PLANNING CONSULTATION RESPONSE

Application No	2026/0480
Proposal	Erection of a detached bungalow and associated works including subdivision of residential garden and alterations to parking arrangements (Custom/Self-Build)
Address	66 Longley Street, Barugh Green, Barnsley, S75 1NT
Date of Consultation Reply	14/07/26
Consultee	Highways DC

A	EXISTING AND PROPOSED SEWERS SHOWN ON PLAN. ROOF HATCH UPDATED FOR PROPOSED PLOT.	29.07.26
REV	DESCRIPTION	DATE
DEVELOPMENT		
LAND ADJACENT TO 66 LONGLEY STREET, BARUGH GREEN		
DRAWING TITLE		
PROPOSED SITE LAYOUT		
DATE	25.04.26	SCALE 1:250@A3
DRAWN	WS	
DRAWING REF	LS-NB-PSL-01	REV A

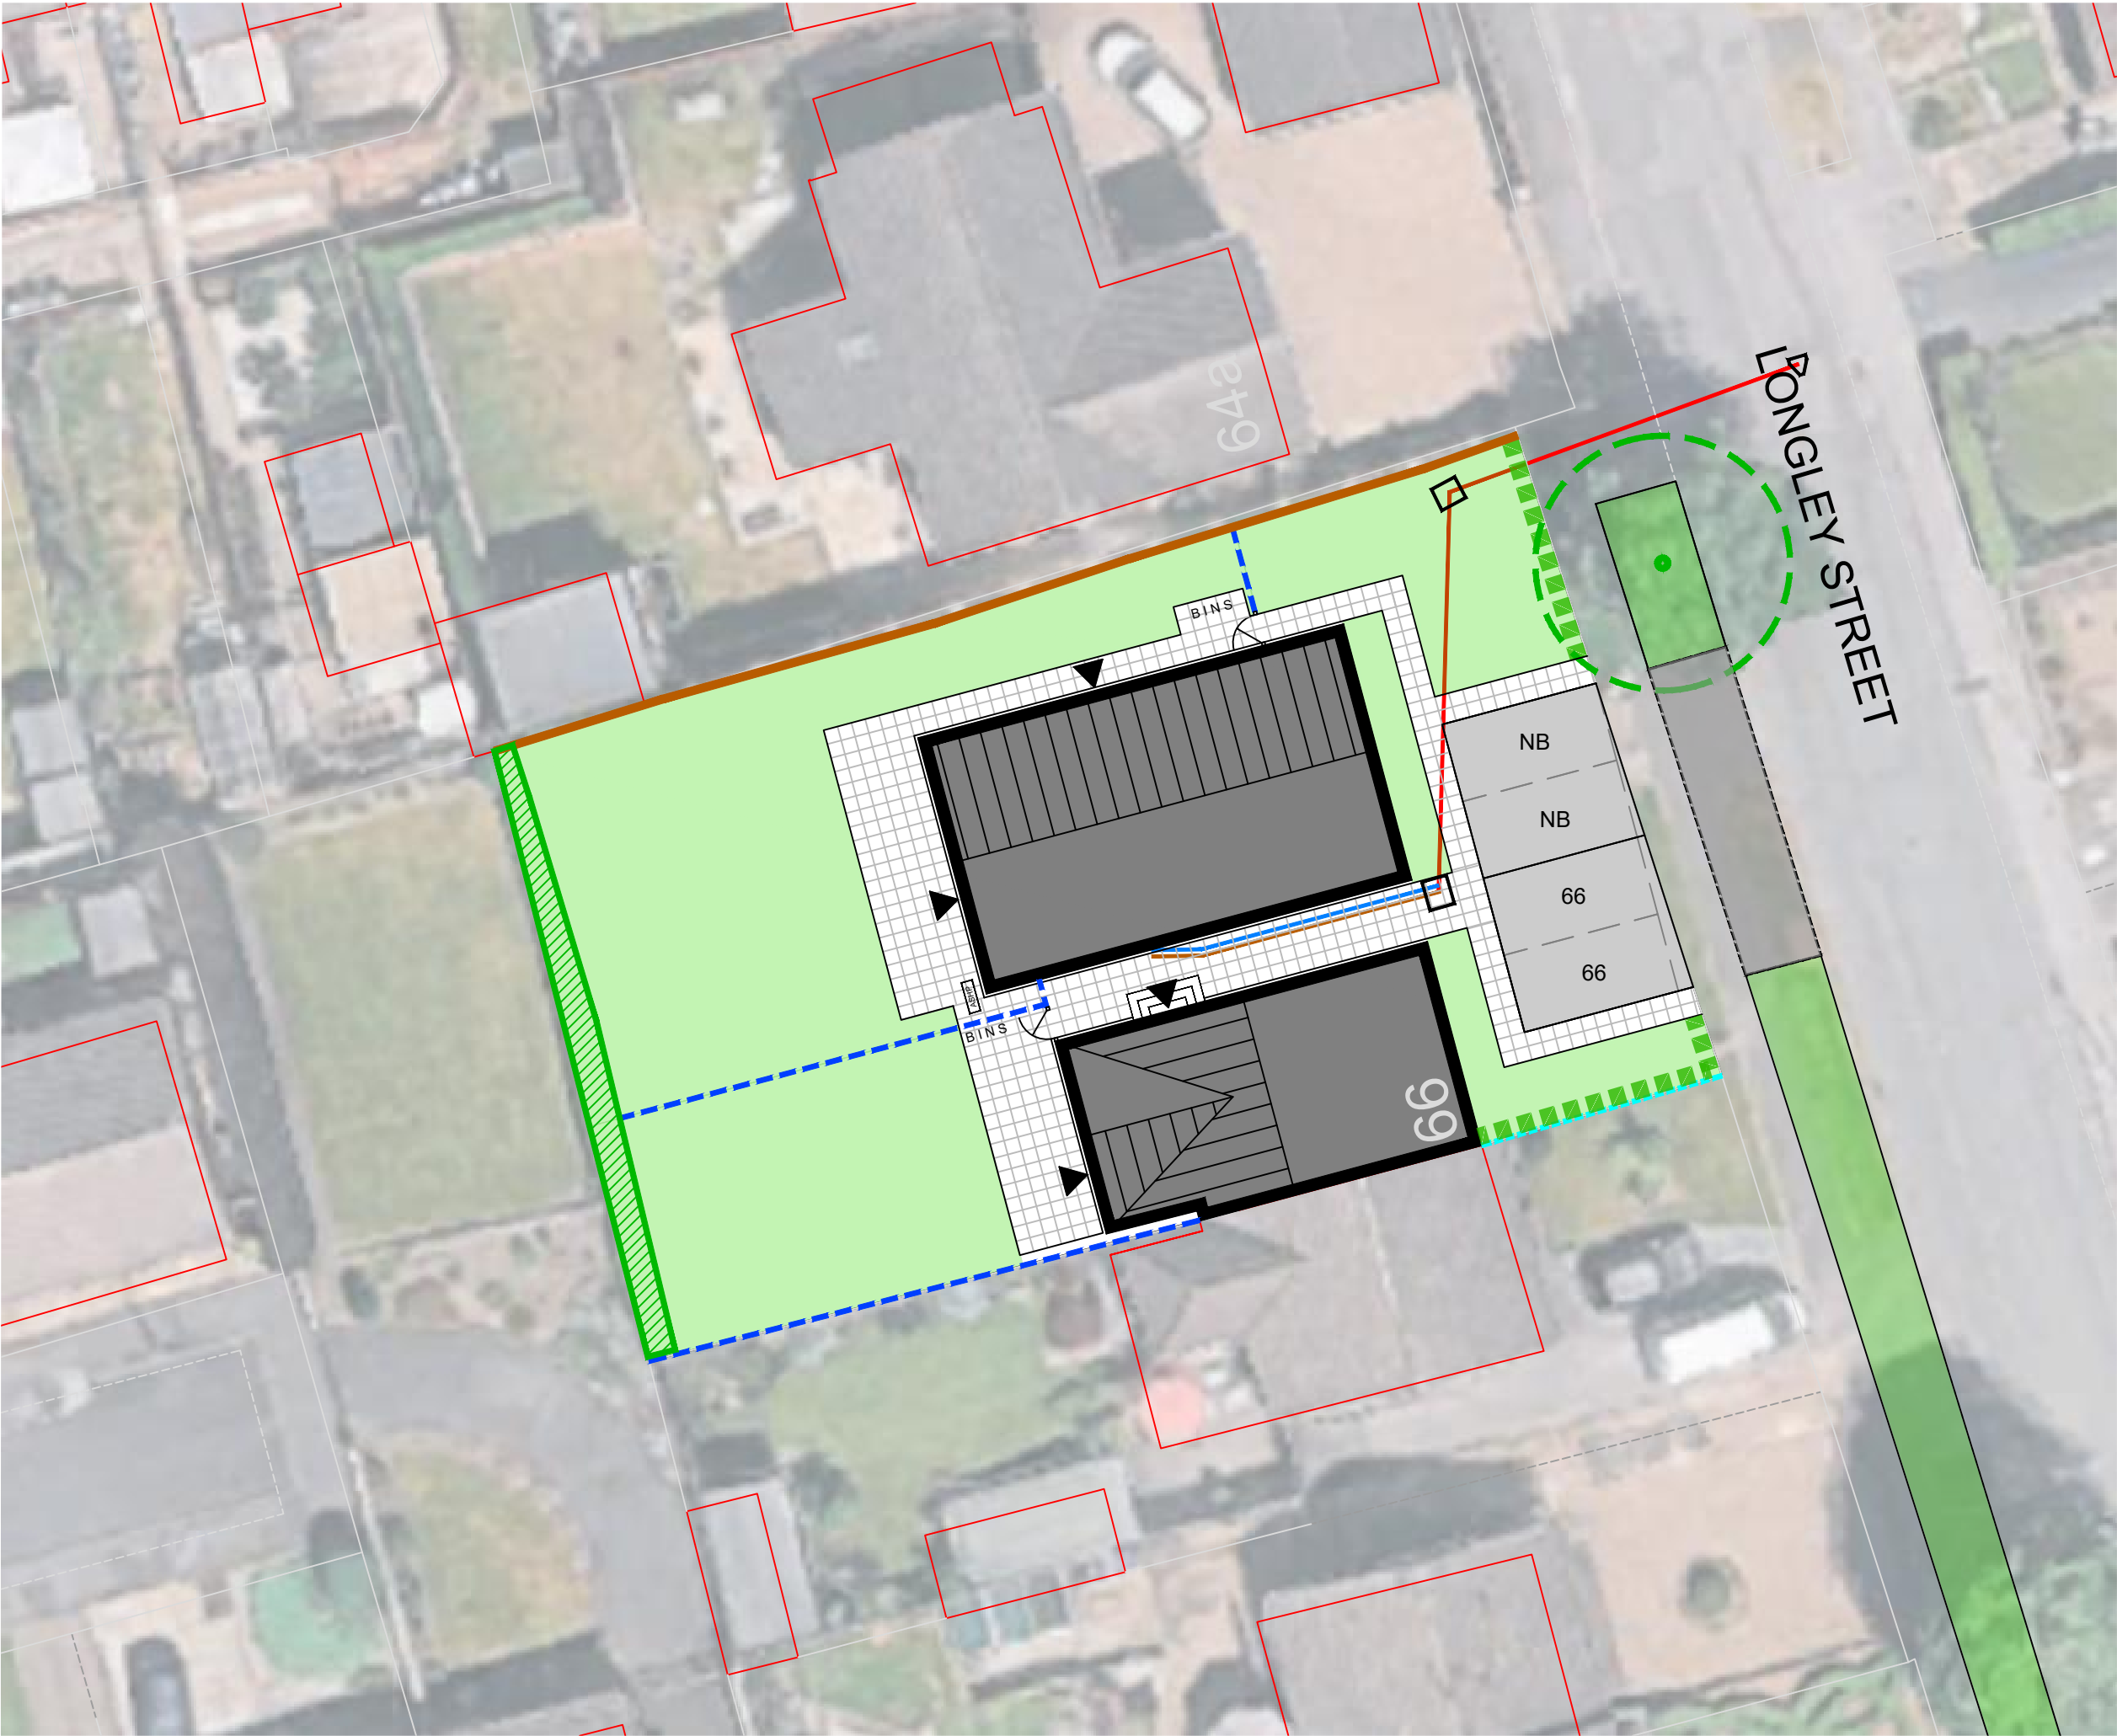
The subject site is currently extended garden area to the side of the existing host dwelling. Drawing no. LS-NB-PSL-01 shows a widened driveway providing two off-street parking spaces for 66 Longley Street, and two off-street spaces for the proposed new dwelling. Bin storage is also shown on the layout plan.

Given adequate parking and refuse storage is provided for each property, HDC officers would have no wish to raise objection to the scheme. However, as there are changes to the parking provision, the below conditions should be included in the decision notice.

The parking facilities as indicated on the submitted plan shall be surfaced in a solid bound permeable material (i.e. not loose chippings) and adequate measures shall be so designed into the proposed access to avoid the discharge of surface water from the site on to the highway.
Reason: To ensure adequate provision for the disposal of surface water and to prevent mud/debris from being deposited on the public highway and to prevent the migration of loose material on to the public highway to the detriment of road safety and in accordance with Local Plan Policy T4 New Development and Transport Safety.

The gradient of the vehicular access/driveway shall not exceed 1 in 12 as measured from the edge of adjacent carriageway.

The parking facility hereby permitted shall not be brought into use until pedestrian visibility splays of 2m x 2m to the back edge of the footway have been provided at the proposed access. Nothing shall be erected, retained, planted and/or allowed to grow at or above a height of 0.6m to the rear of the footway which would obstruct the visibility splays. The visibility splays shall be maintained free of obstruction at all times thereafter for the lifetime of the development.
